Epping to Thornleigh Third Track Proposal. Application number SSI 5132.

4/we object to the Epping to Thornleigh Third Track Proposal and consider that the EIS is inadequate and does not address the full impact of this proposal. It will cause untold damage to the health of residents and to the fabric of the Beecroft Cheltenham Heritage Conservation Area. Do not approve this project, reconsider the alternatives and protect the community.

Figure S.6 Cross-section and elevation - New Cheltenham Station concourse building (see also S.5 for artist's impression)

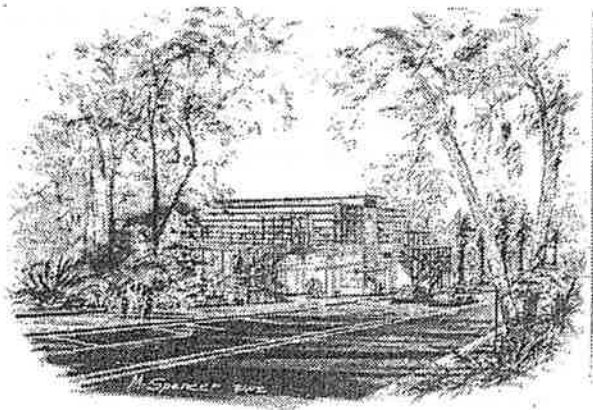
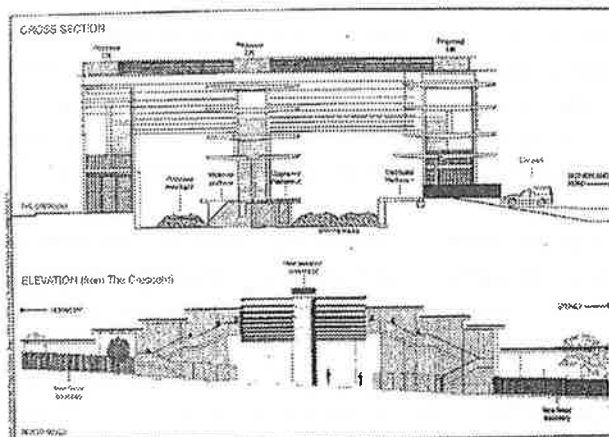
- The proposed redevelopment of Cheltenham Station shows no regard for the HCA. The visual impact of the proposed 13m high glass and steel concourse is totally unacceptable in this HCA.
